From: Melanie Schwecke
Sent: Tuesday, 19 December 2017 4:39 PM
To: Thomas Piovesan
Cc: Deana Burn; Nikki Matthews
Subject: RE: Oakdale West Industrial Estate (SSD 7348) and Erskine Park Biodiversity Corridor - OSL comments

Regarding the development of the Goodman site – Oakdale West Industrial Estate, OSL has the following comments:

Figure 8 Plan showing riparian corridor widths for Oakdale West Precinct

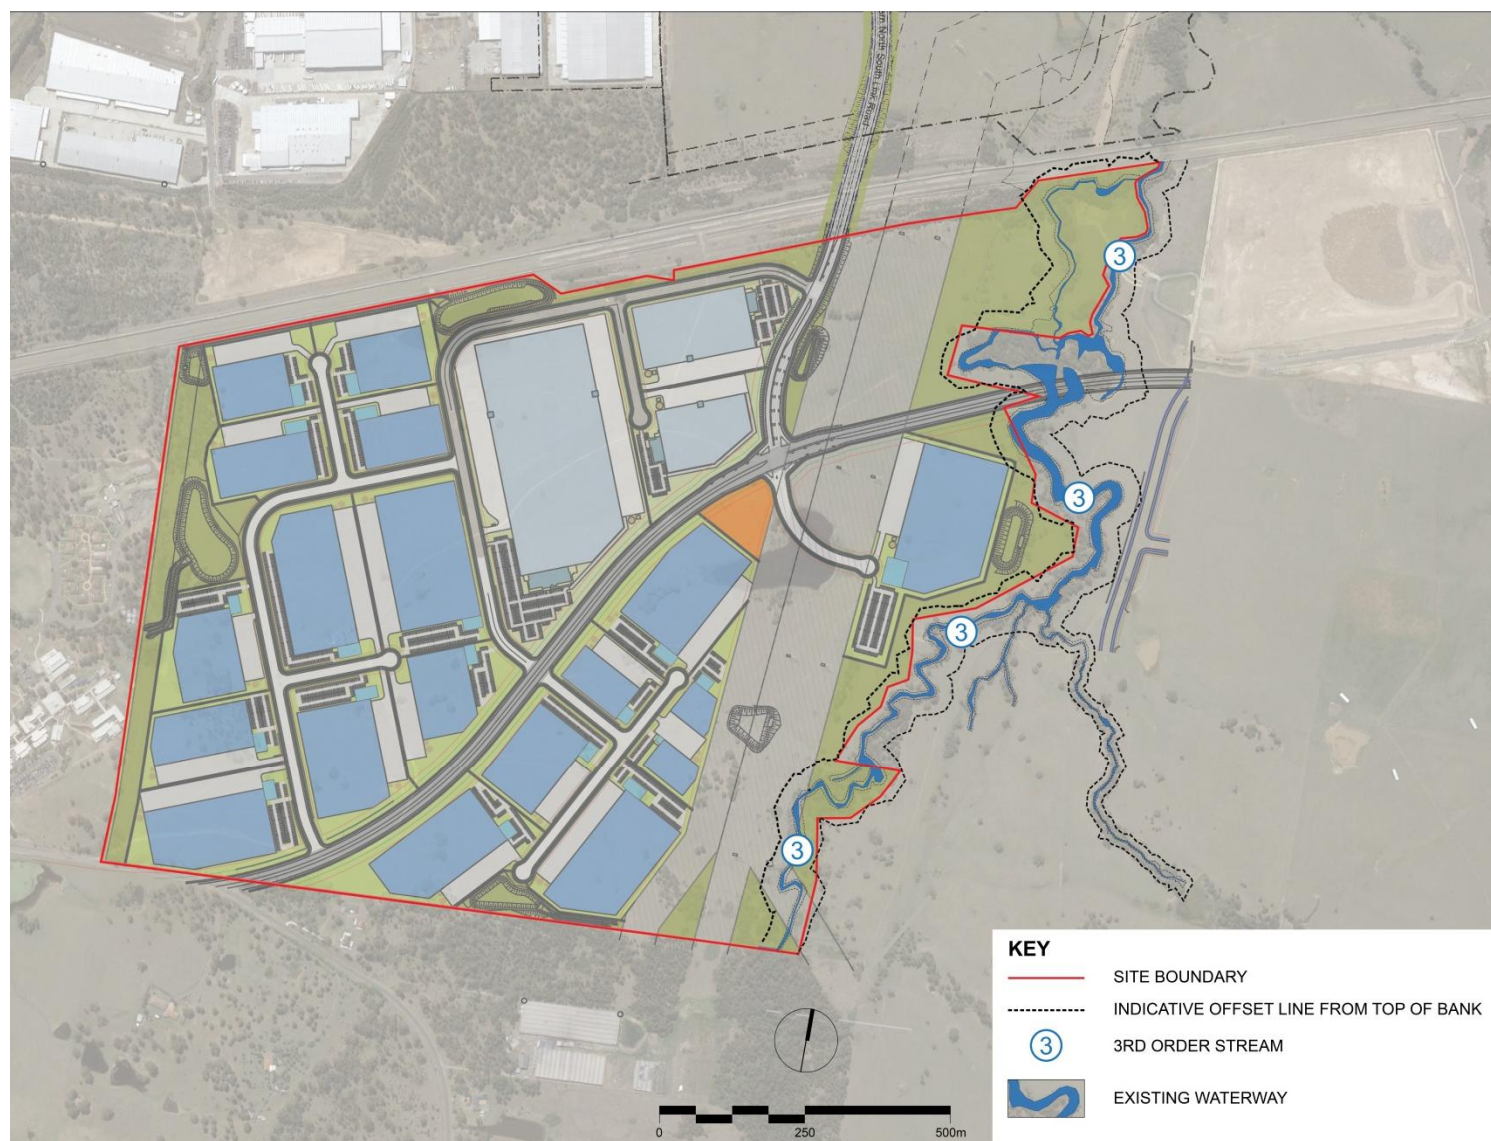
- OSL has discussed basins being located within the biodiversity corridor land, and do not believe that they offer sufficient biodiversity to allow them to be located within the riparian corridors of the creeks (Ropes/South Creek), it is suggested that the basin proposed within the Ropes Creek riparian corridor be relocated outside of the corridor.

- The bioretention basin being located within the corridor limits the vegetation community type that can be reinstated. The basin is not rehabilitating/restoring pre-existing indigenous vegetation community - the basins plants do not appear to be from the River Flat Eucalypt Forest (formally known as Sydney Coastal River Flat Forest), nor Shale Plain Woodlands vegetation communities.

- The basin and its associated end use are likely to impact the existing native vegetation communities located on the corridor land due to: the placement of the basin, type of plants to be placed in the basin, and the reduction in conservation land and connectivity through the introduction of plant species and landscape features not consistent with the River Flat Eucalypt Forest and Shale Plain Woodlands communities.

Figure 3: Concept Design: Part B - WNSLR

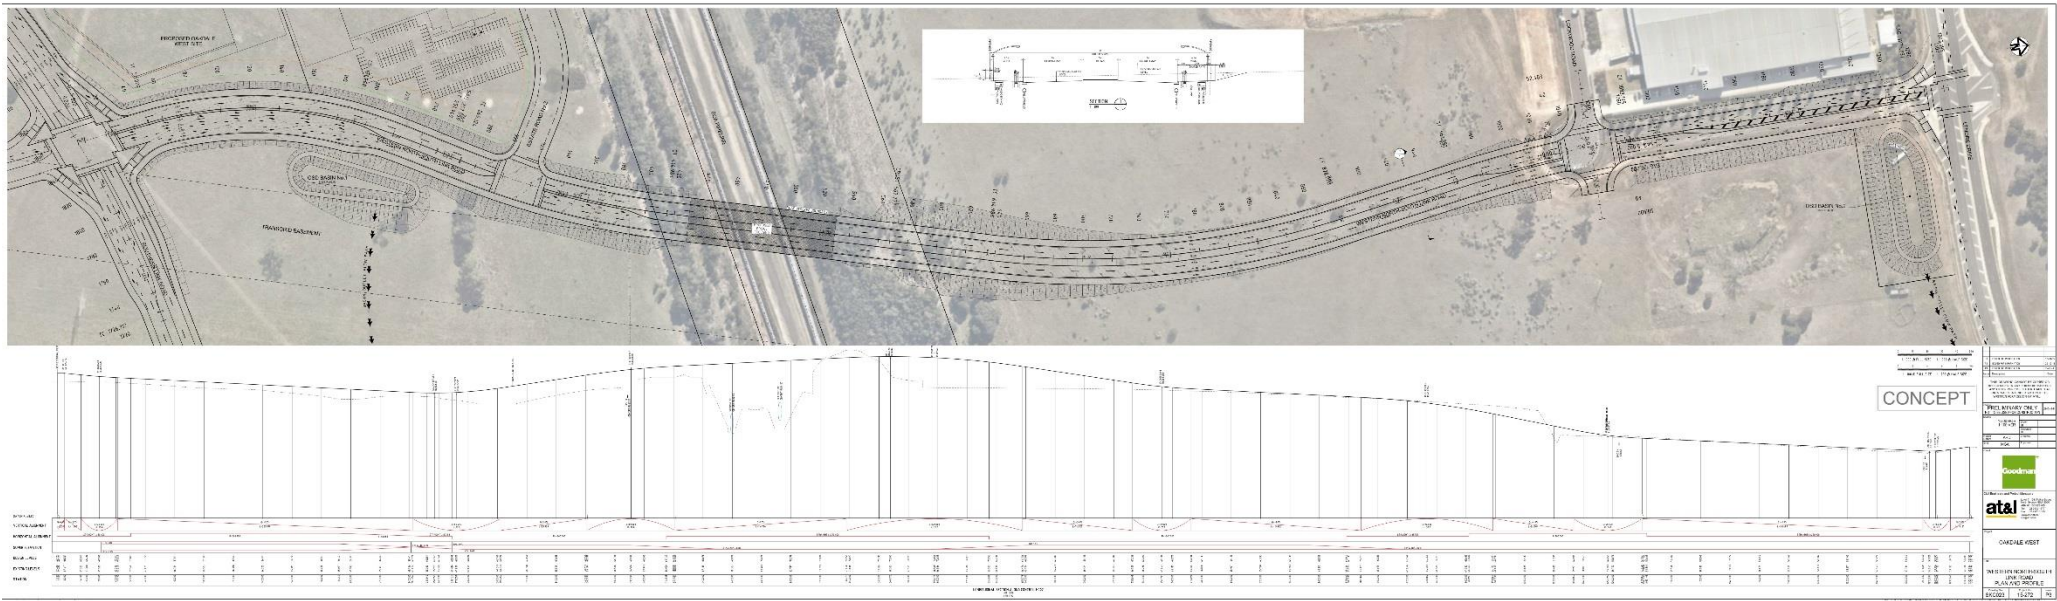
- The proposed link road that transects the Erskine Park Biodiversity Corridor Land appears to remove biodiversity land from the corridor – with no correspondence regarding the offset of this loss of corridor land. – this is unacceptable and need to be rectified by the applicant to ensure there is no net loss of the biodiversity corridor land. A bridge spanning over the biodiversity corridor land would be acceptable to OSL, ensuring that vegetation can still grow underneath the bridge.
- The proposed basin associated with the link road also needs to be located outside of the biodiversity corridor land.
